RE: CoS Response to Submissions for SSD 7388 for the redevelopment of the IMAX Theatre and surrounds, 31 Wheat Road, Sydney

Attachment A - Reconciliation of City of Sydney issues raised in response to the exhibition of the redevelopment of the IMAX Theatre and surrounding public domain (SSD 7388)

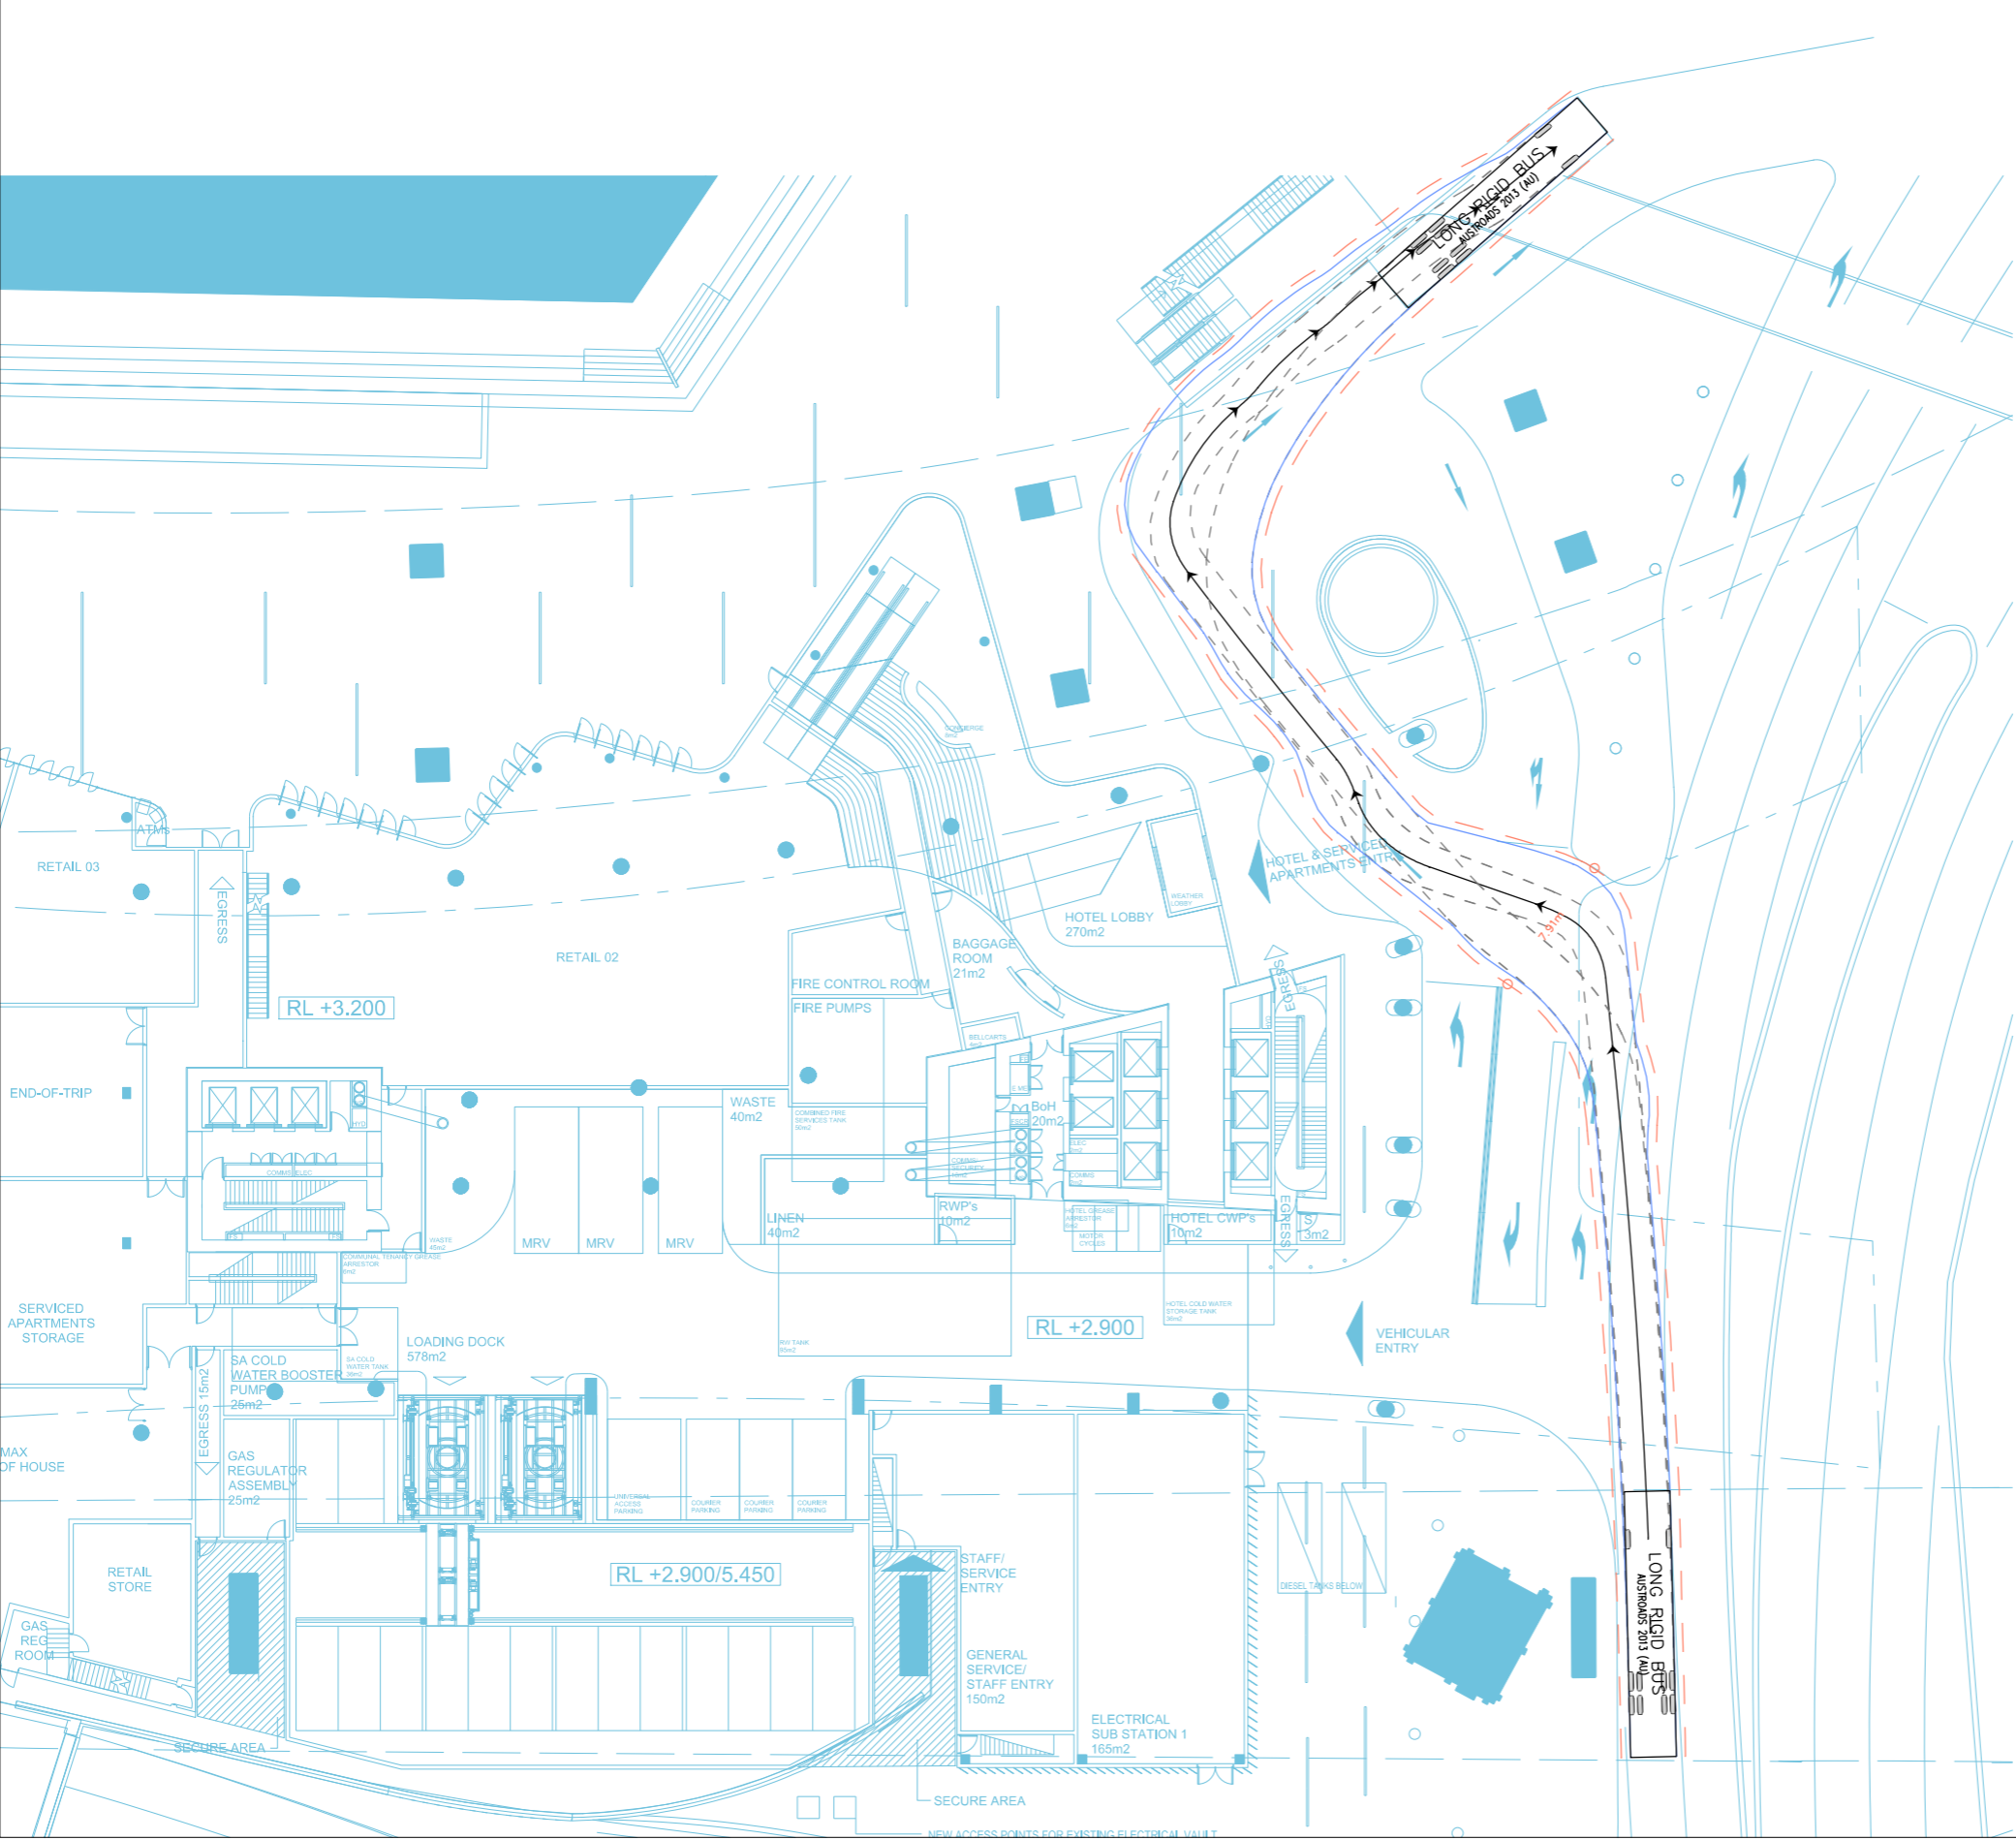
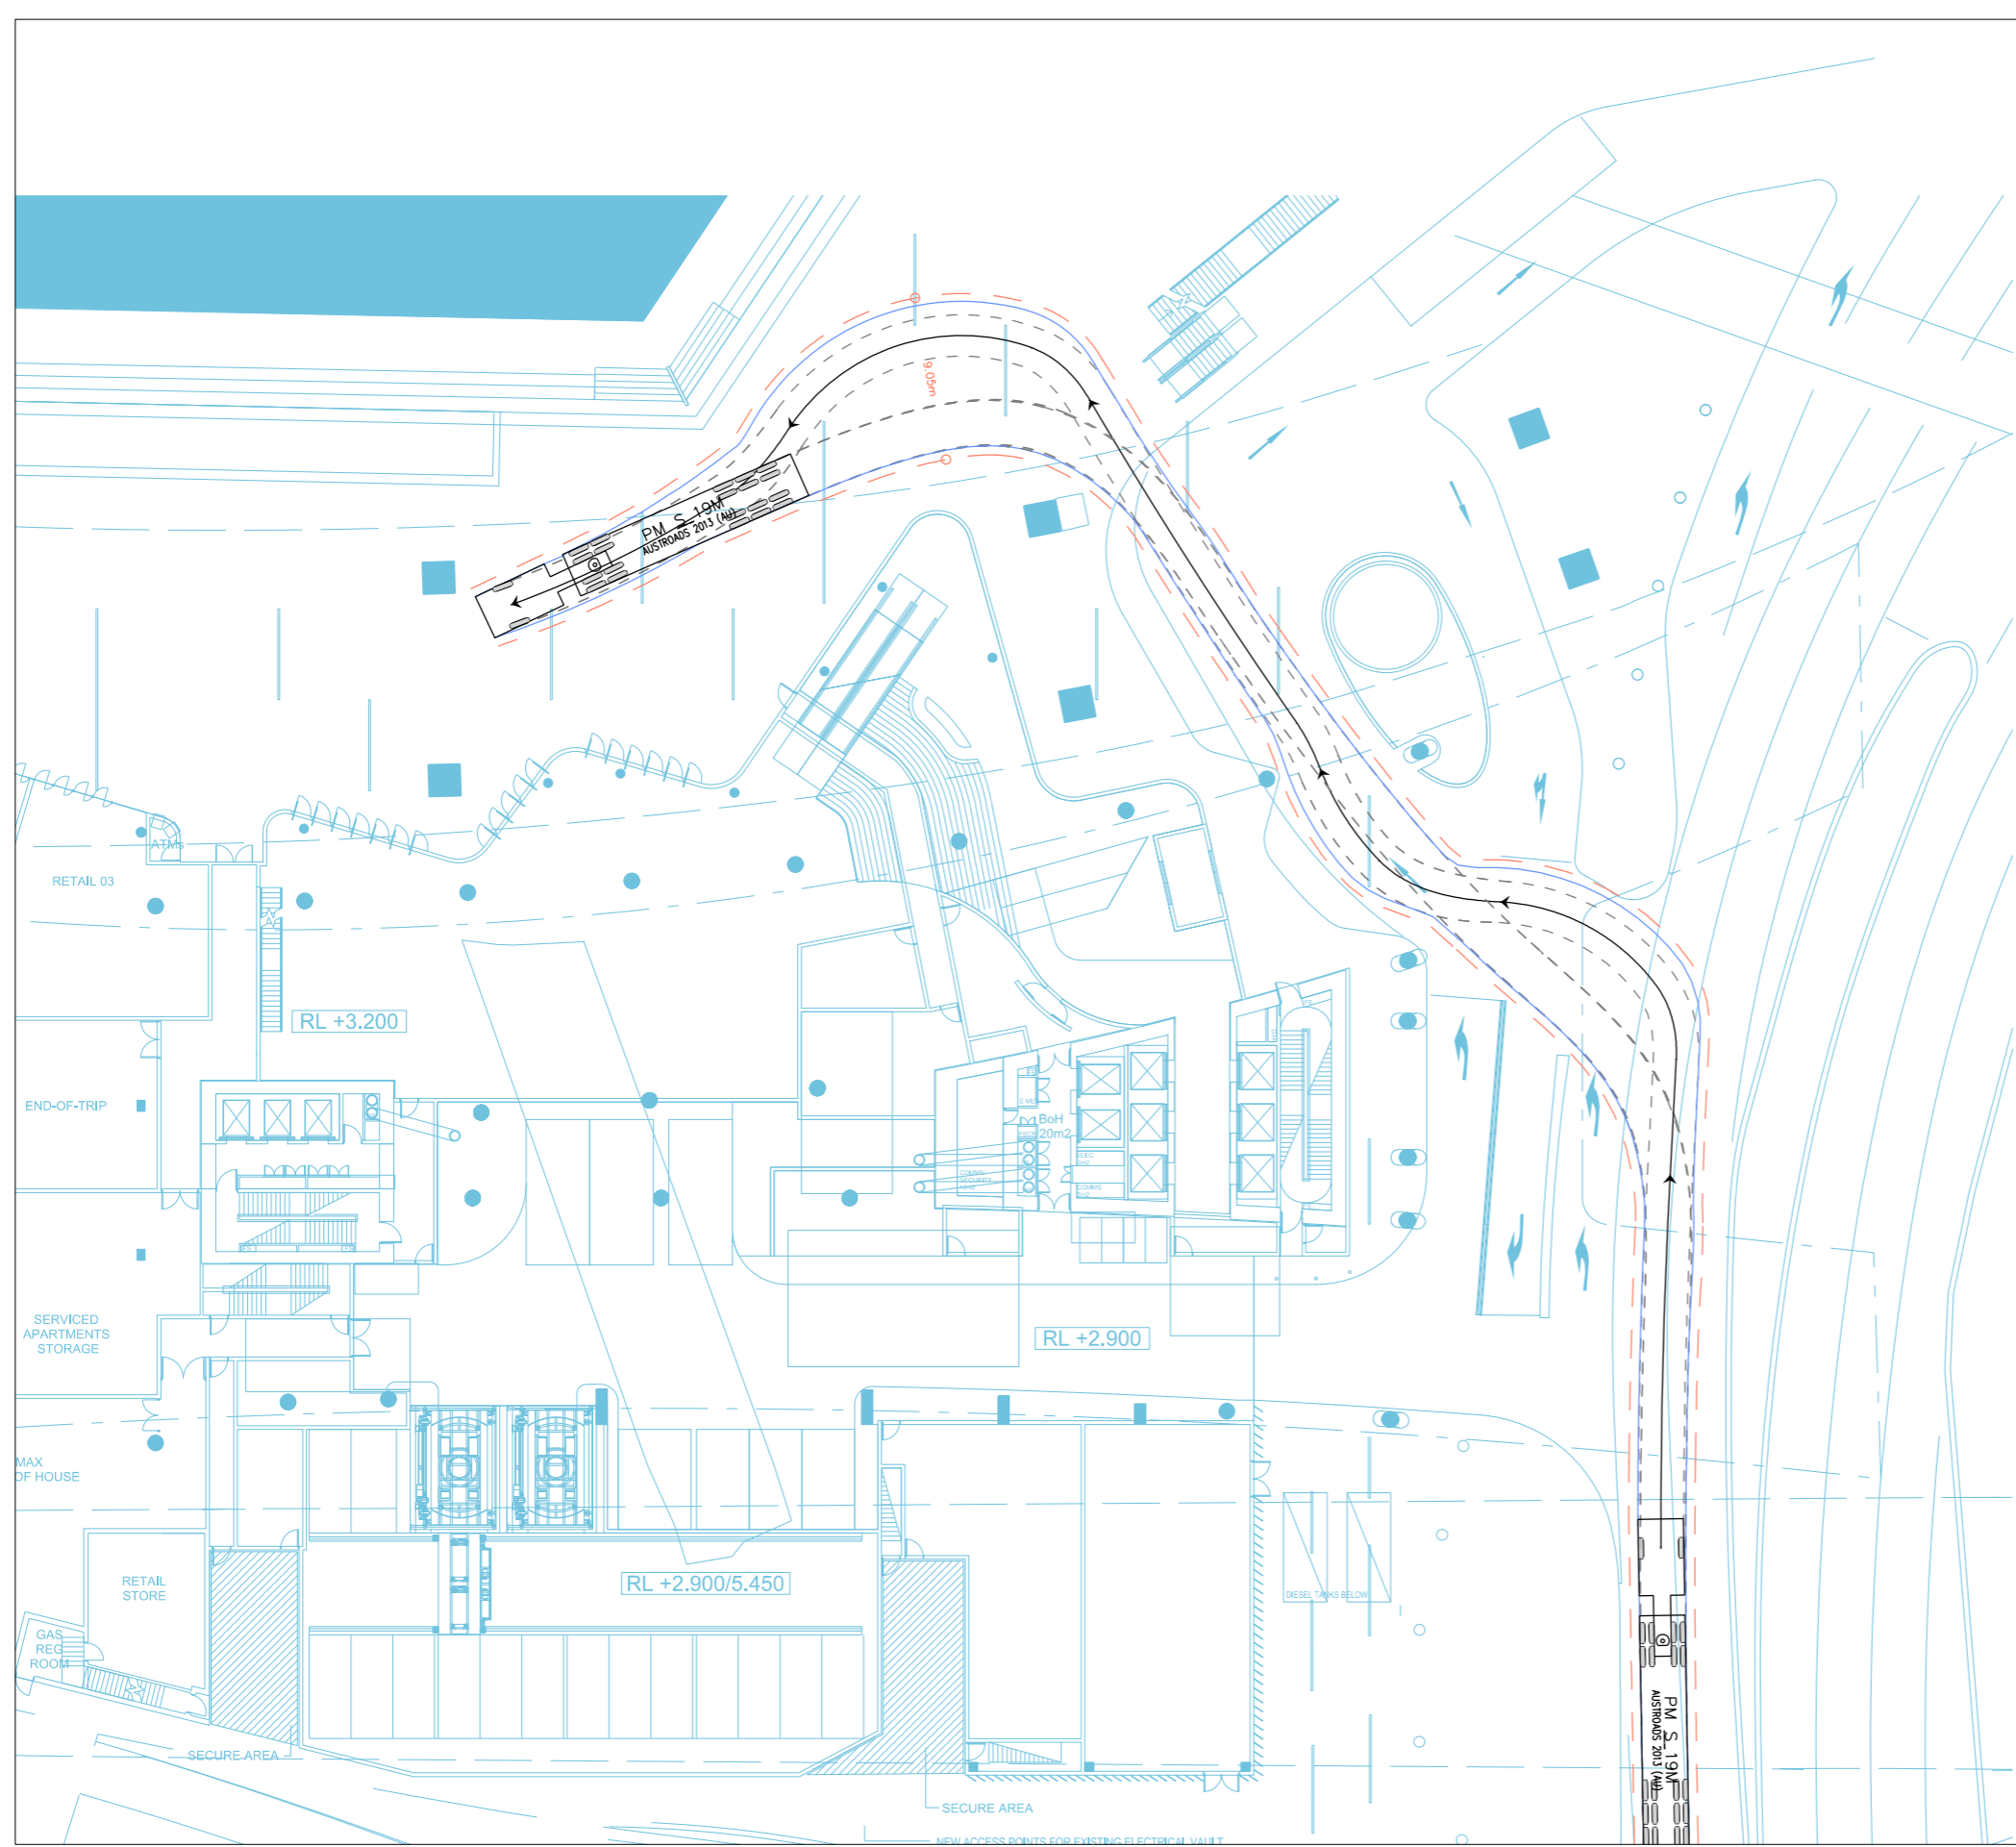
34. It is unclear what Appendix A, sheets 2 and 3 of the Traffic Impact Assessment are trying to demonstrate. Council does not support heavy rigid	No comment or response provided was provided to the specific issues raised by the City. The below comments have been provided in	No	It is understood that the 19m semi-trailer access via the waterfront area may be

Issue	Applicants response	Issues addressed?	City's contention
<p>vehicles such as semi-trailers entering the pedestrian footway area adjacent to the water front (if that is what is proposed). This area is highly pedestrianised and would not be suitable as a shared zone.</p>	<p>response to issues raised by Transport for NSW, who raised similar concerns to the City. <i>To maintain Darling Harbour special event access, the site incorporates the ability for a 19m semi-trailer to access the foreshore area. The associated swept paths to satisfy SHFA requirements were included with the Transport Impact Assessment and does not reflect day-to-day operation.</i></p>		<p>a SHFA requirement. The provision of 19m semi-trailer access via the waterfront area is not supported by Council.</p>
<p>35. A Loading Management Plan should be provided to demonstrate how the dock will be managed. The on-site loading area is to be available to all tenancies of the particular building (i.e. hotel, lounge bar, restaurant, service apartments, shopping, retail, function centre, cinema etc). This shall be managed either by a schedule showing all tenants when they can use the area, or by a register managed on site to allow tenants and residents to reserve a time period for their deliveries.</p>	<p>No comment or response provided was provided to the specific issues raised by the City. The below comments have been provided in response to issues raised by Transport for NSW, who raised similar concerns to the City. <i>A detailed management plan for the porte cochere and car stacker/ loading area would be prepared as discussed previously to address any potential conflict between any loading vehicles and car stacker queued vehicles. Loading and unloading will be undertaken outside of peak hours (where possible) when there is limited demand for the car stacker. It is also anticipated that service vehicles would be able to travel adjacent to any queued vehicles in order to access the loading area. Vehicle manoeuvring in the basement area would be managed by an attendant or security personnel. The vehicle positions shown within the porte cochere vehicle bays are indicative only. The bus swept path is a worst case situation (14.5m long rigid bus which are not used the Sydney Explorer service and would only be occasional pre-arranged coaches for the hotel). The swept path analysis shows there is adequate spare width within the porte cochere area for a 14.5m long rigid bus to pass parked vehicles, however the resultant vehicle positioning at the bus stop would be considered further during detailed design to deliver an appropriate outcome.</i></p>		<p>As noted above, concerns are raised that there is not the vehicle capacity to address all the vehicle access needs of the site. A loading management should be provided up front so a proper assessment of the feasibility of the plan can be determined. As discussed previously, the management plan must address the cumulative impact and management of the porte cochere, car stacker and loading area and address any potential conflict between uses such as conflicts between queuing loading vehicles and car stacker vehicles. In this regard, the queuing of vehicles waiting to use the mechanical stacker is not supported within a loading dock area. Alternatively, the queuing of service vehicles within the loading dock is also not supported.</p>
